Letter No.C4/17176/91

Sub: MMDA - Planning clearance - Proposed  
construction of lodging house under  
MUDF scheme at S.No.237pt. of Thiru-  
vottiyur village - Approved.

2. The approved plans are numbered as C/PC/18/91 sent  
herewith for further action at your end along with Planning  
Permit No.13826, dated 30.12.91.

SITE PLAN  
 SCALE 1:500

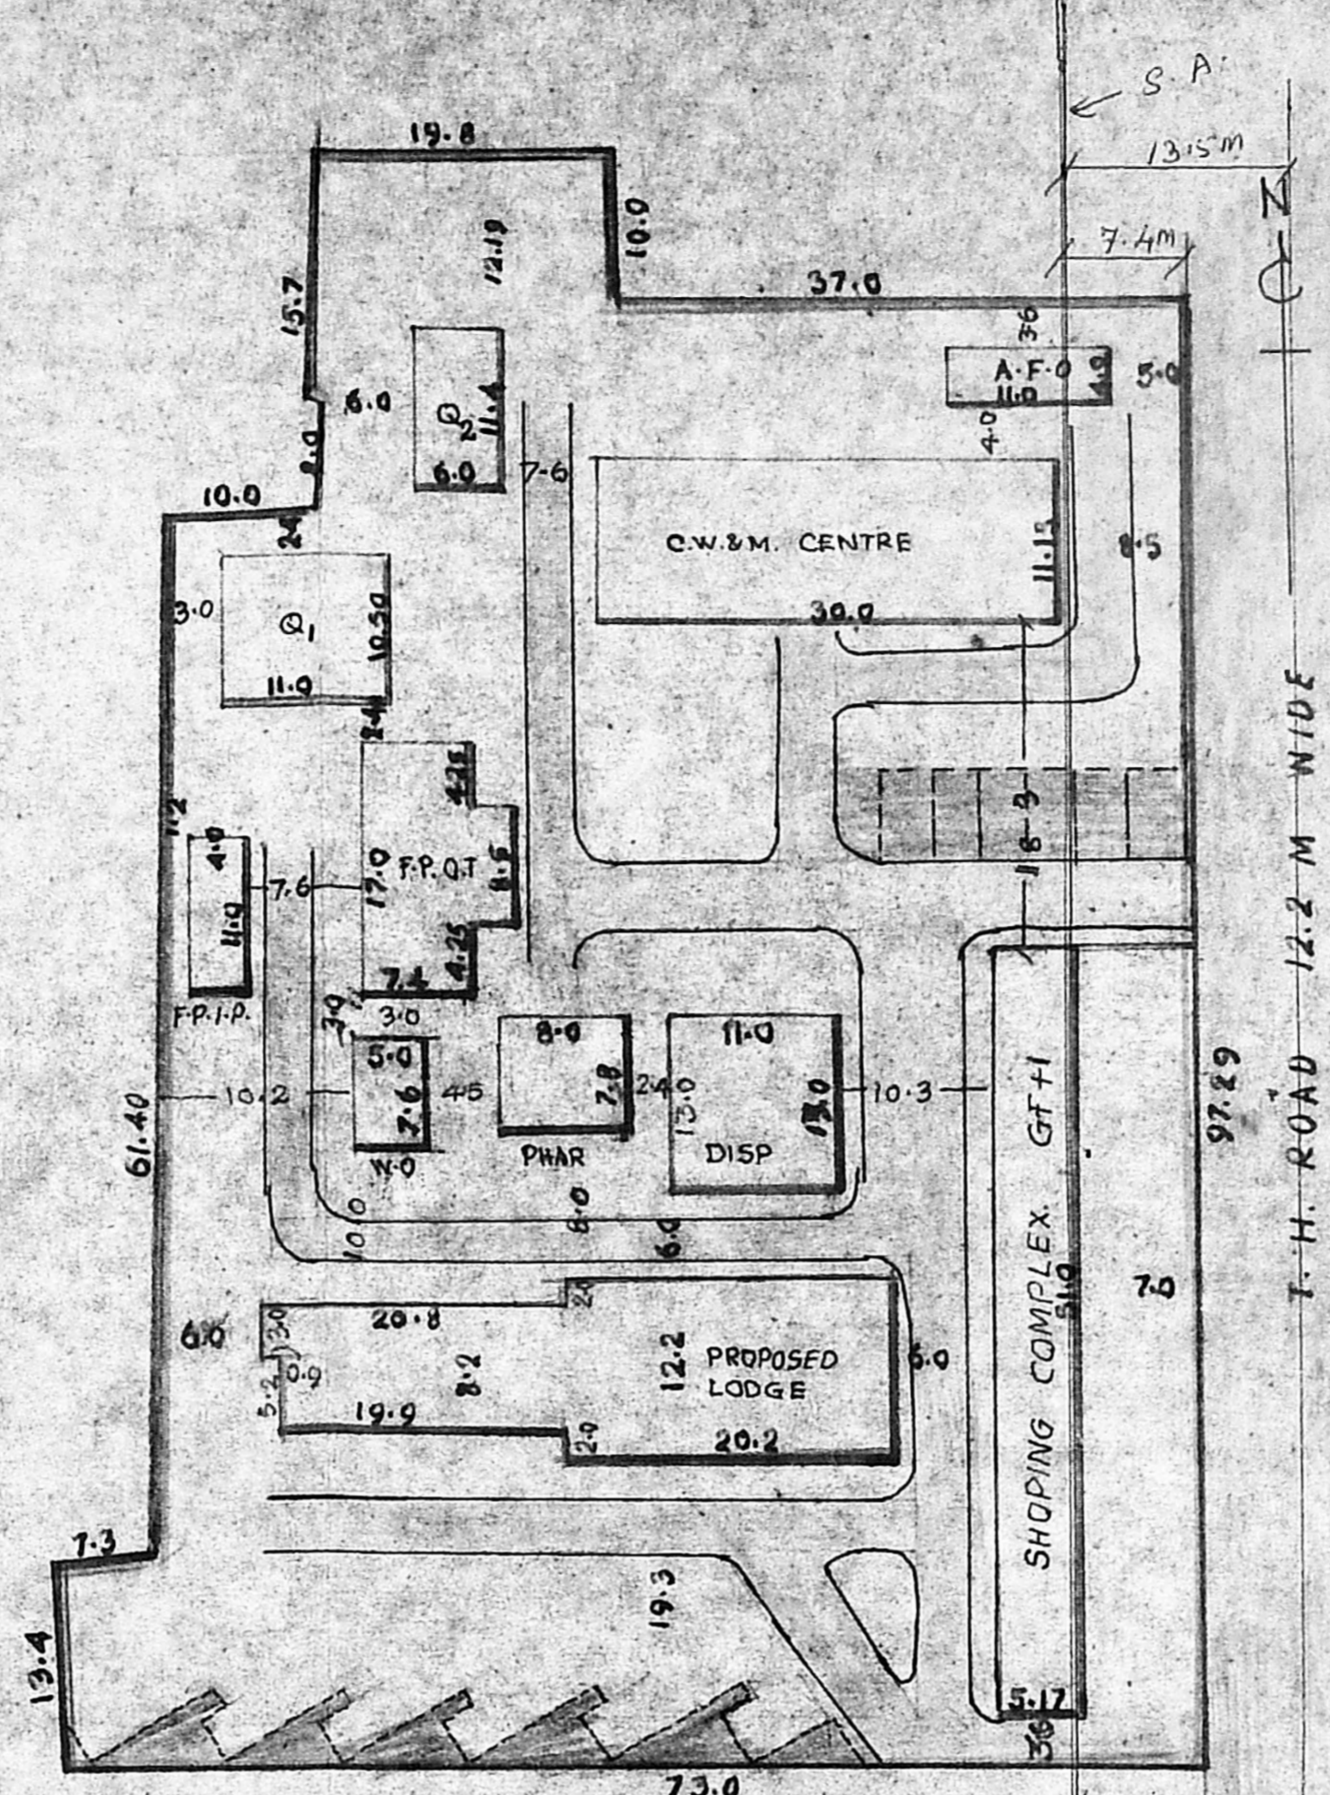
The proposal received in the reference cited for the  
construction of lodging house at Survey No.237pt. of Thiruvottiyur  
village has been examined and found approvable. But the existing  
shopping complex and AFO unit violate street alignment by 0.4M  
and 2.4M respectively. Therefore the issue of planning permission  
(for the proposed building) does not confer any approval to  
AFO unit.
